WEST SUSSEX COUNTY COUNCIL CONSULTATION

TO:	Arun District Council FAO: Michael Eastham
FROM:	Stephen Gee WSCC - Highways Authority
DATE:	18 October 2021
LOCATION:	Land off Arundel Road Angmering BN16 4ET
SUBJECT:	A/207/21/PL Variation of condition following grant of A/122/19/OUT relating to Conditions Nos 4 - approved plans and 16 - vehicular access.
DATE OF SITE VISIT:	n/a
RECOMMENDATION:	Advice / No Objection
S106 CONTRIBUTION TOTAL:	n/a

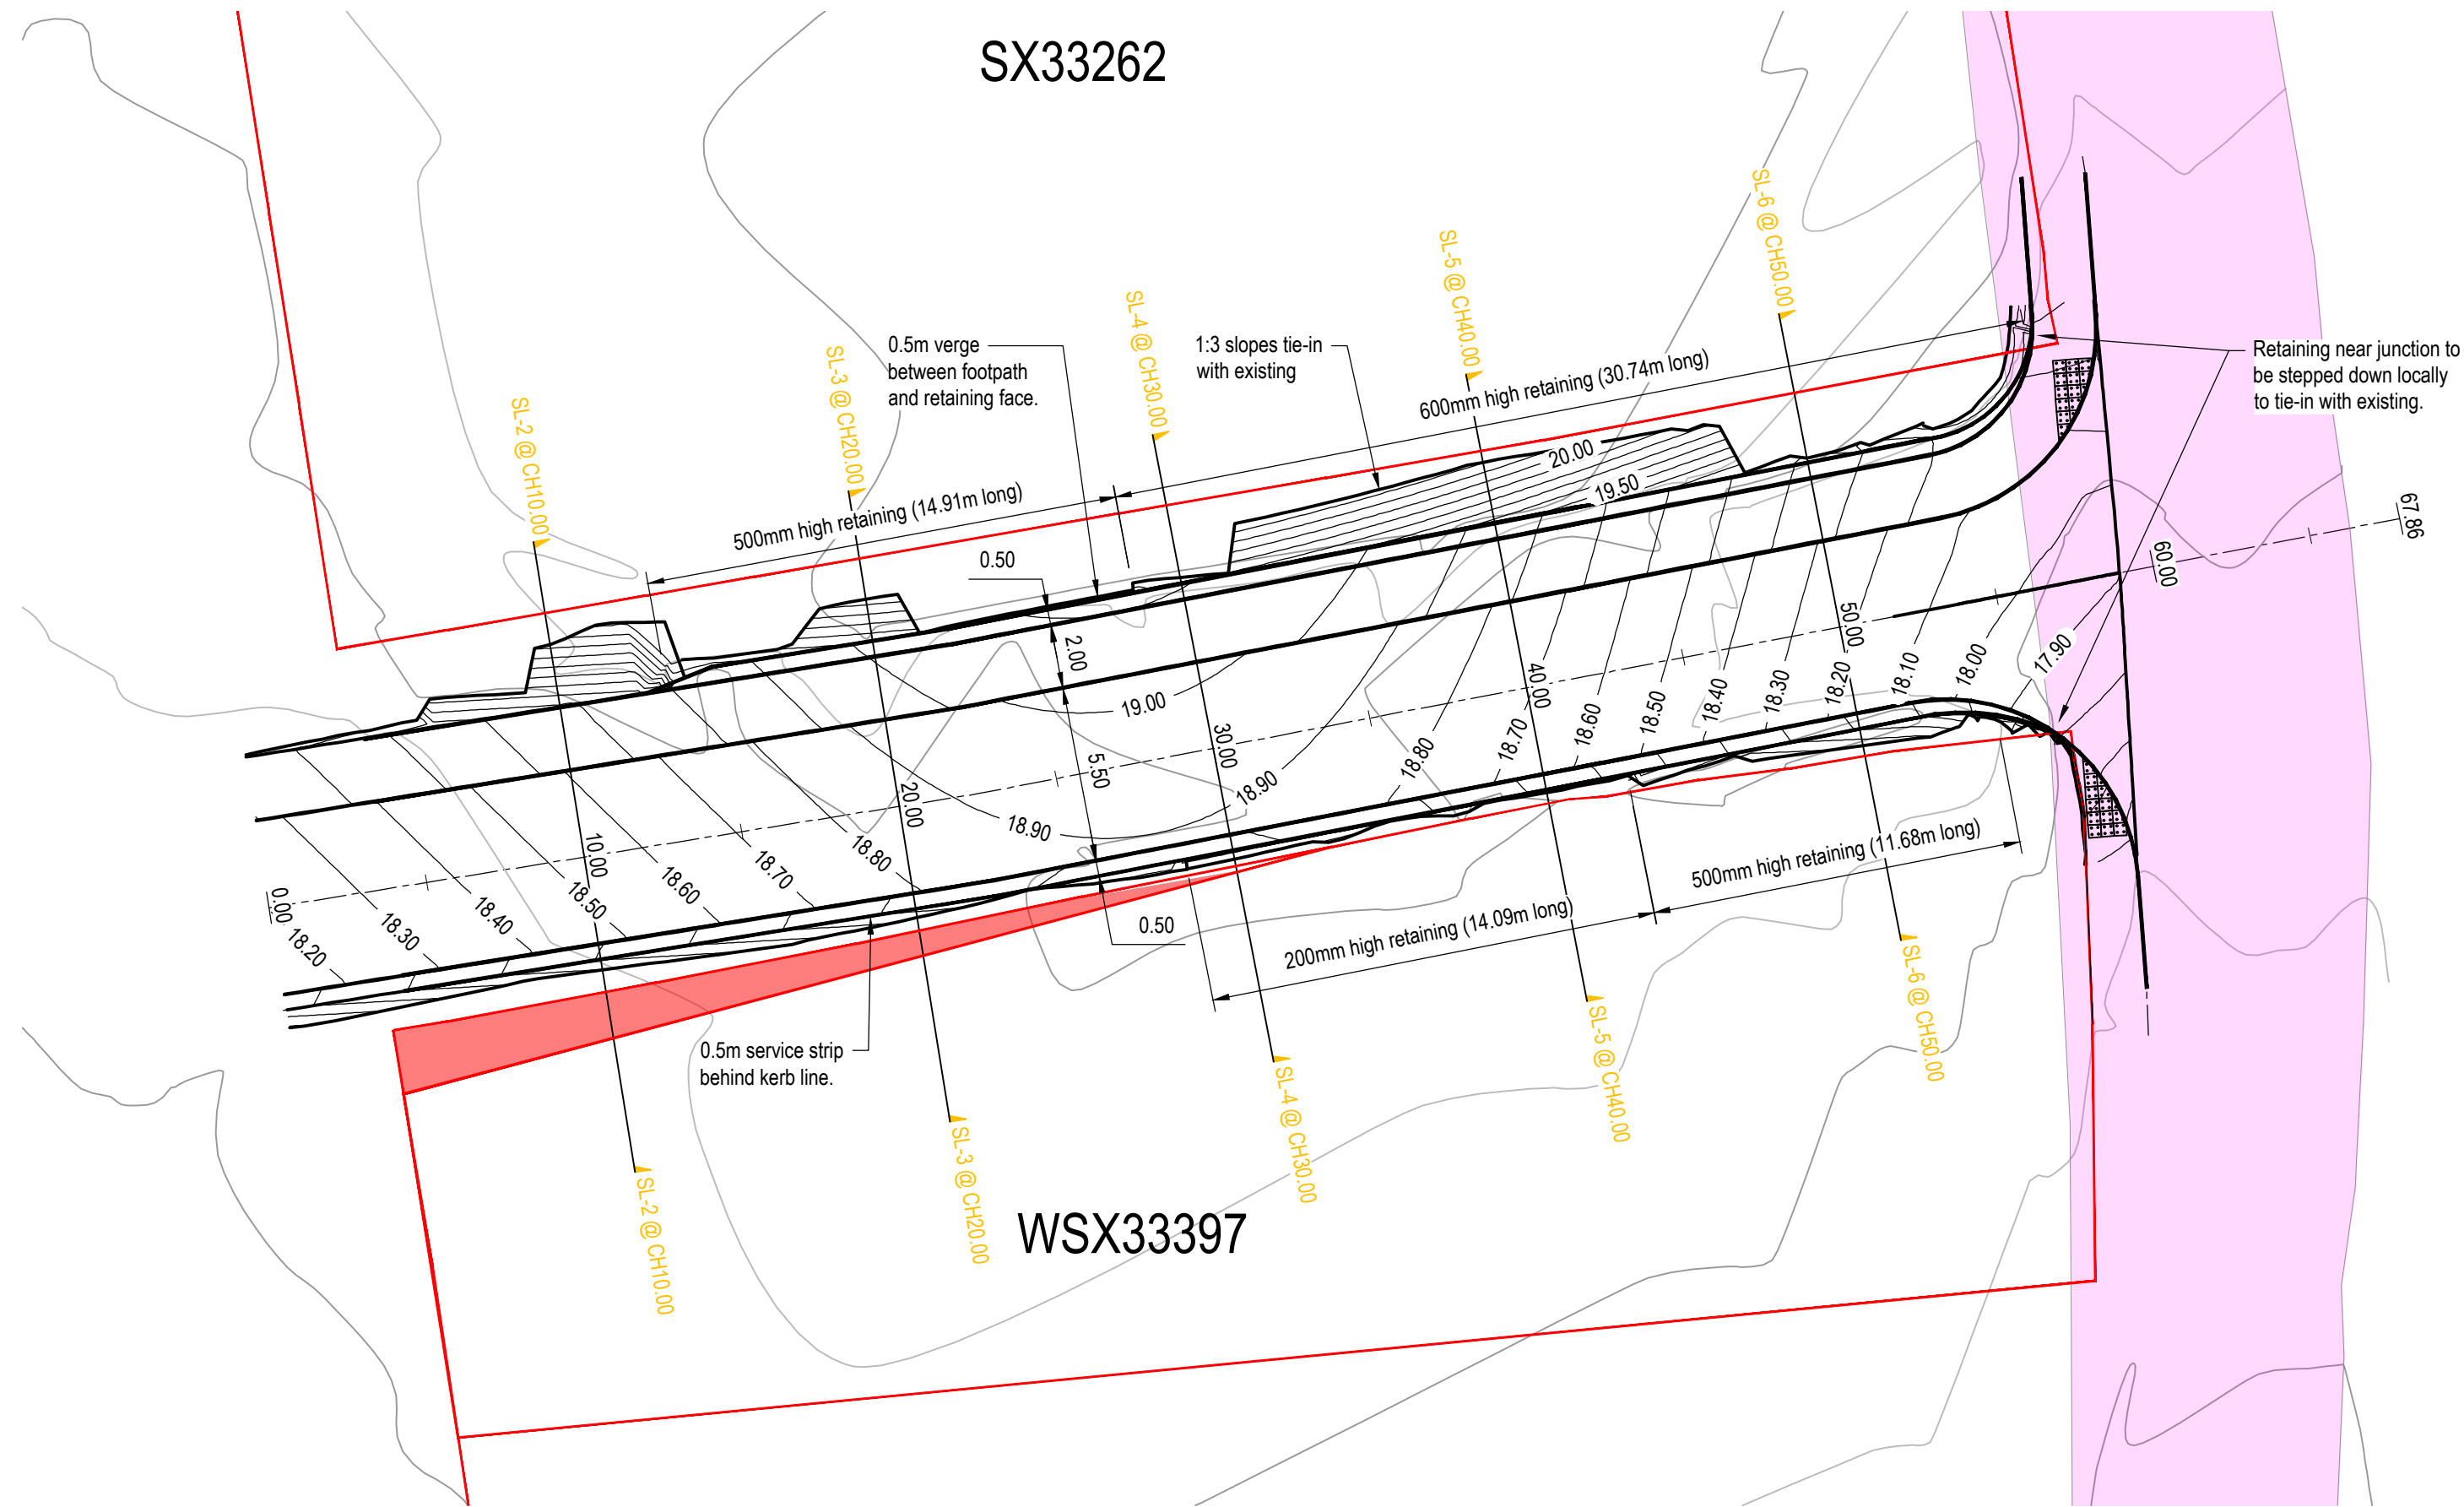
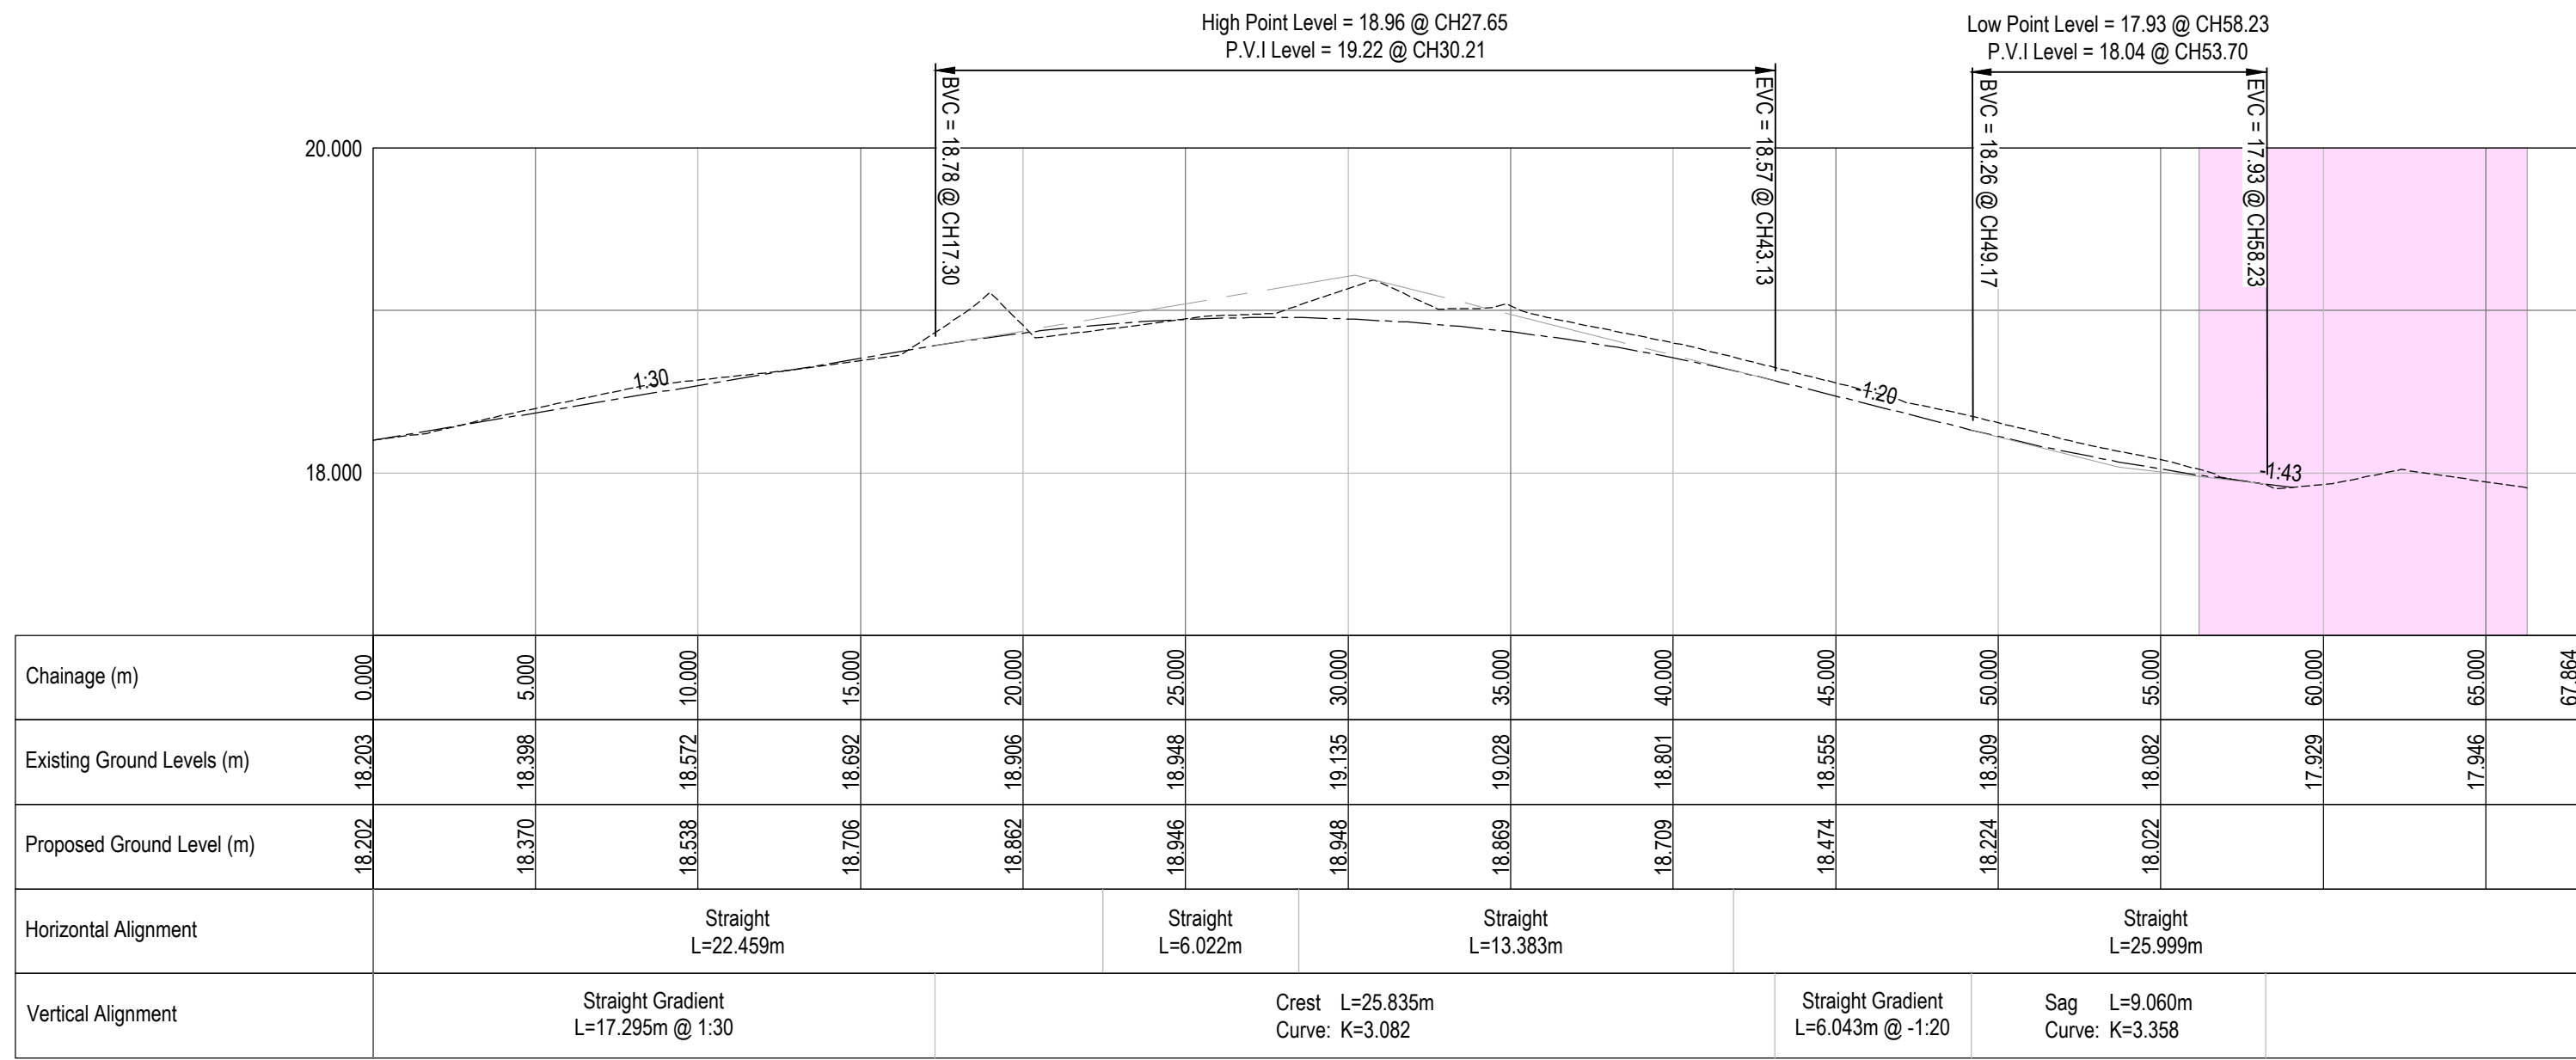
No objection is raised to the variation of condition 4 and 16 concerning the amending of the southern (and existing) vehicular access. The changes result in a 2m footway being provided on the northern side of the access and .5m service margin on the southern side. Alternative pedestrian accesses also exist on the northern vehicular access, to the PROW to the west of the site and potential future links to the south via the playing fields/future sports provision.

No details have been provided as to if there are any existing services within the southern service margin, should there be or if any are proposed it would be WSCC preference that a 1m margin is provided. As the changes to the approved access are limited a stage 2 Road Safety Audit would be required at detailed design stage.
